Historic England

Our ref: P01564307

3 April 2024

**OS PARCEL 4347 EAST OF PIPAL COTTAGE, OXFORD ROAD, KIDLINGTON  
Application No. 23/01233/OUT**

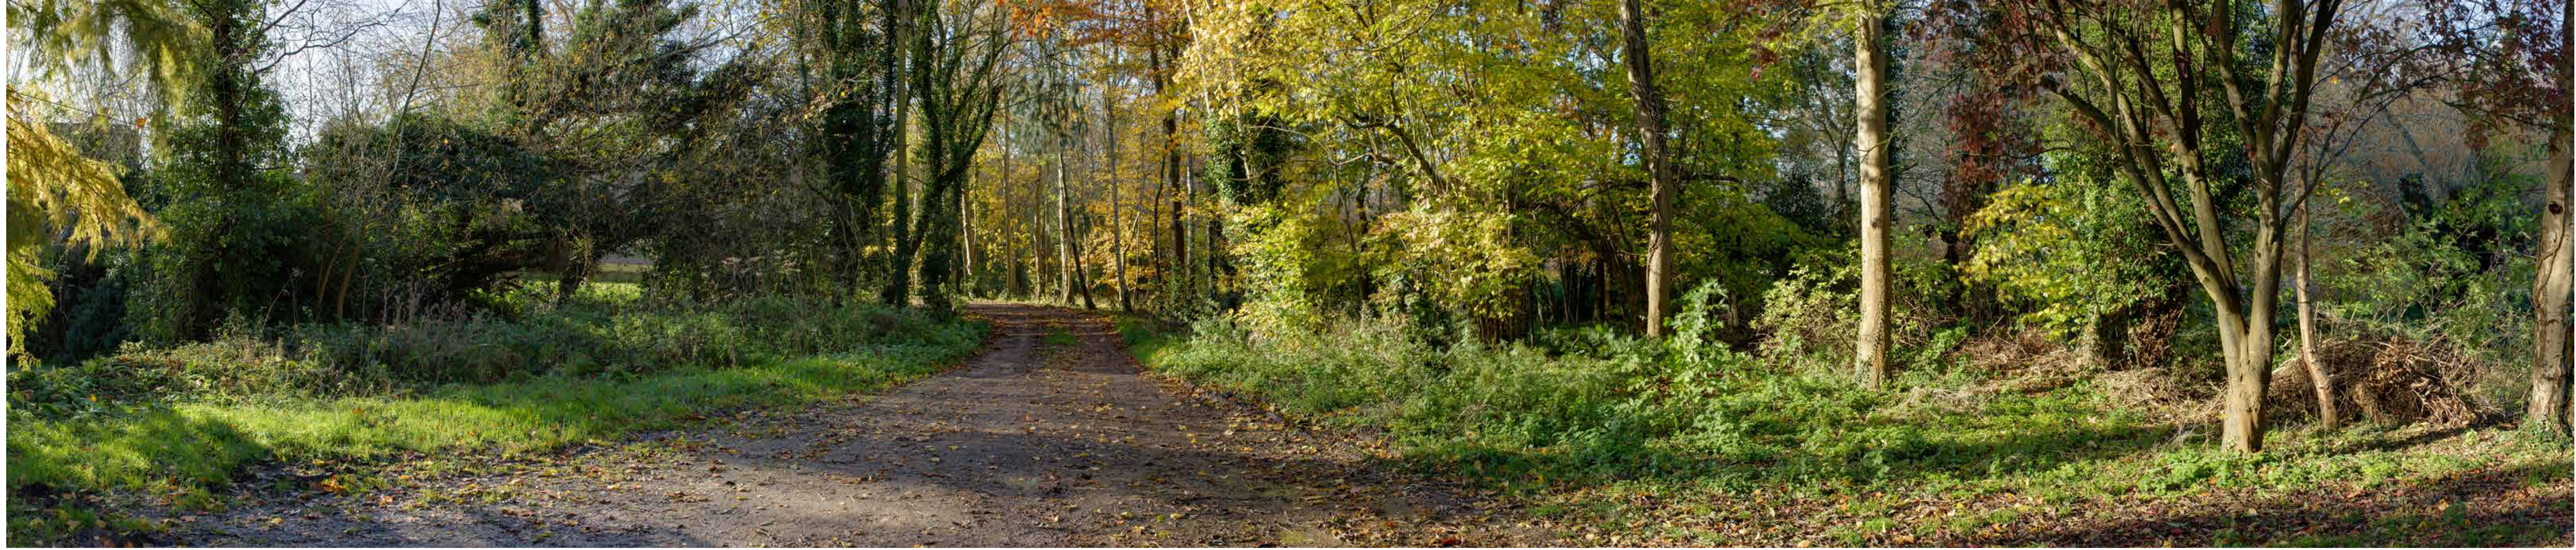
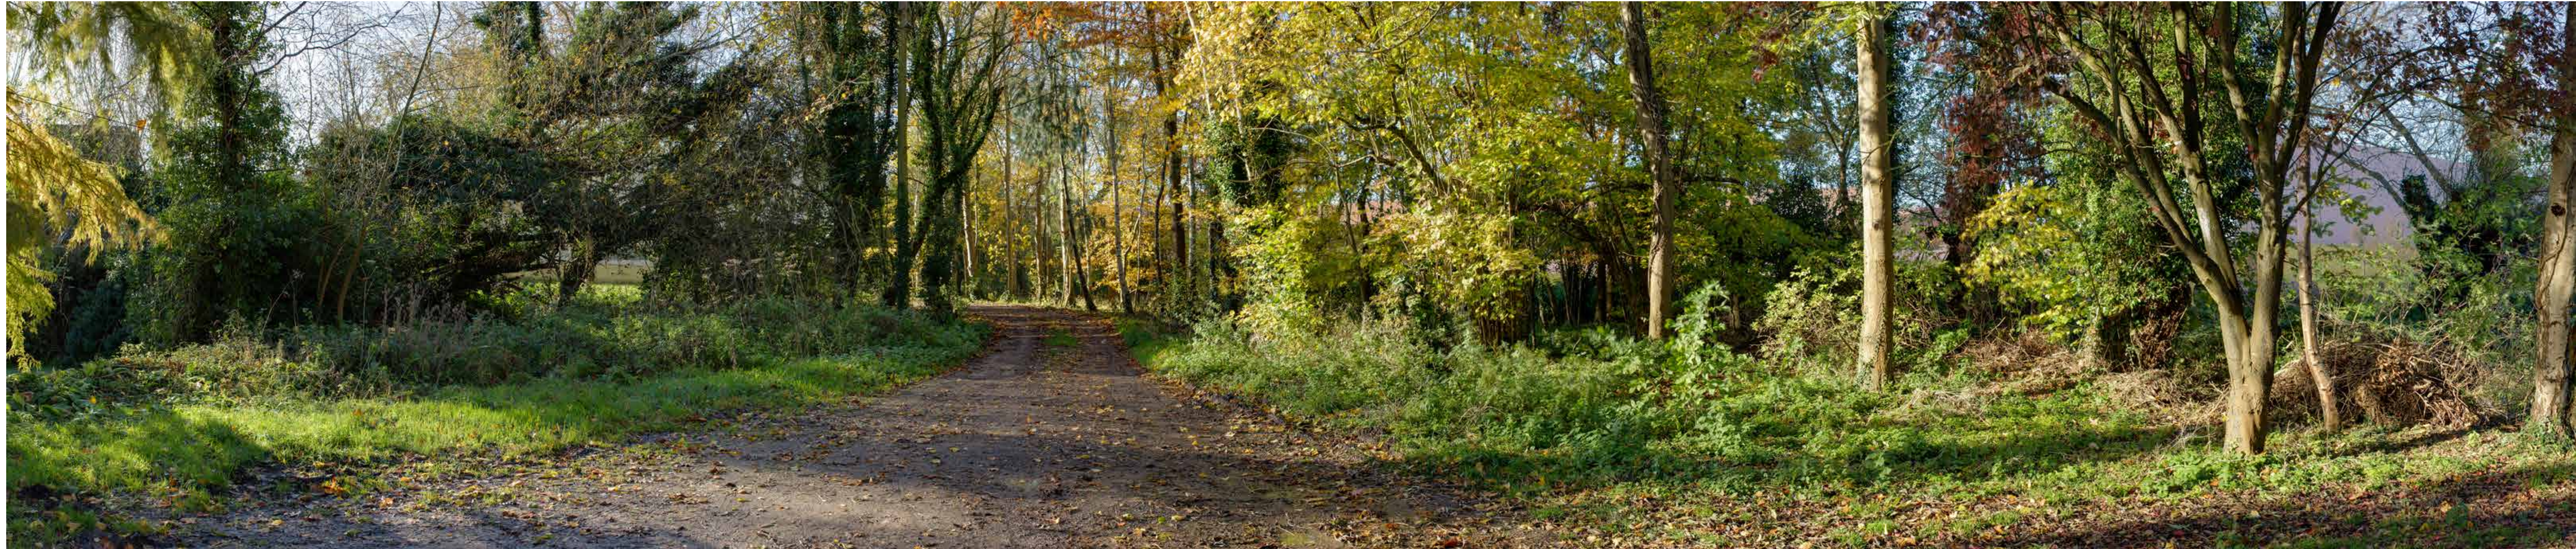
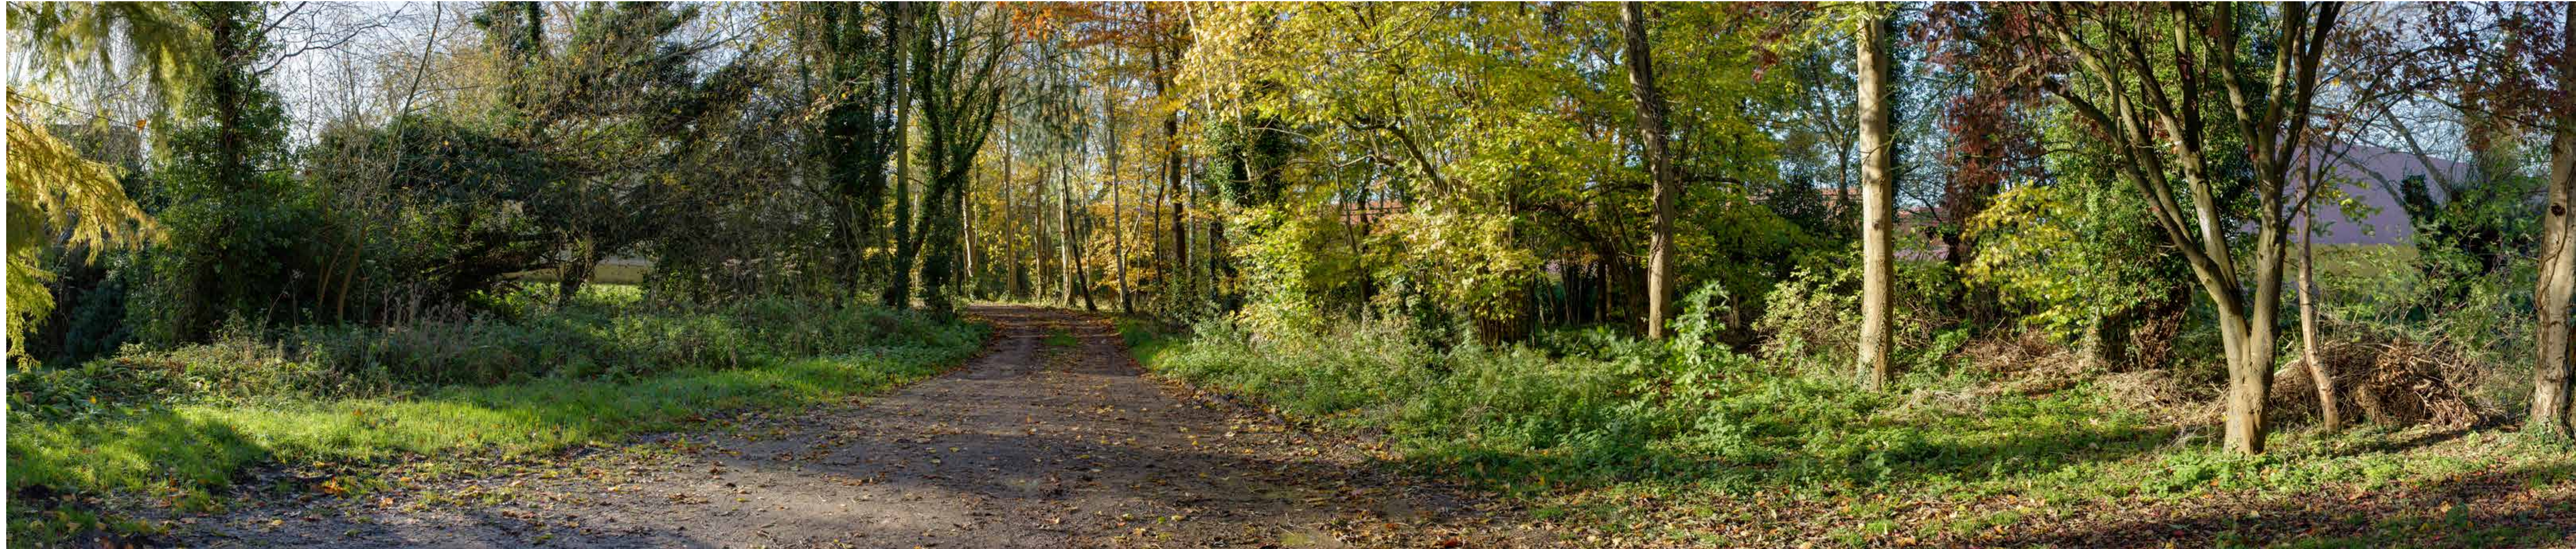
The additional verified views submitted from within the gardens of St Frideswide and the Public Rights of Way around it indicate that the proposed development has the potential to be highly visible and/or appreciable from this Grade II\* building. Views along the Public Right of Way (views 4, 5 and 7) to the south offer open views back and to St Frideswide. As the visuals demonstrate the development is likely to have a close relationship with St Frideswide, removing the rural feel to the west of the house, and replacing it with a more suburban character even once the proposed screening has established.

Of particular concern is the proposed school, which may rise to 3 storeys/11 meters and is sited particularly close to the farmhouse. Views 4 and 5 shows the school would rise up directly behind the historic farmstead in the more open views from the south, whilst views 1 and 2 show the development may appear in glimpse views through and above the tree screening. Even if the development doesn't have a visual impact, its proximity means its highly likely it would still be appreciable, such as through noise and lighting. This changes the character of the place from an enclosed rural to one that is more suburban in nature. For these reasons and those set out within our letter of 6 October, we remain of the opinion that the proposed development would affect the setting of St Frideswide, causing harm to its significance.

The location and orientation of the school particularly encroaches on the listed building and would dominant it in the surrounding landscape. We appreciate there are difficulties in reducing the mass and height of the school building, which by their nature are large functional buildings. We would therefore question if this could be relocated elsewhere. I note the Development Brief (August 2022) suggested the school be located further to the north and a greater green buffer to the west of St Frideswide established through a mix of open green space and allotments and two storey dwellings further west. In our view this has the potential to provide a more gradual transition between the suburban nature of the development and rural character of this historic farmstead, which would be preferable. Whilst we appreciate this option may impact the amount of houses the site could deliver, we note the application seeks to deliver 800 homes which is more than the 690 the allocation requires. A lower density could be adopted to allow more open rural space around the farmhouse of St Frideswide.

We appreciate there are ways this harm can be mitigated (to a degree) under reserved matters through screening and the final design and mass of the development, however at this stage we are not persuaded that enough has been done to minimise or avoid the harm caused by the proposed scheme. NPPF paragraph 201 requires you to seek such opportunities, and we encourage you to do this before weighing any remaining harm against any public benefits of the application. In the first instance it would be advisable to seek a reduction in height of the buildings closest to the farmhouse.
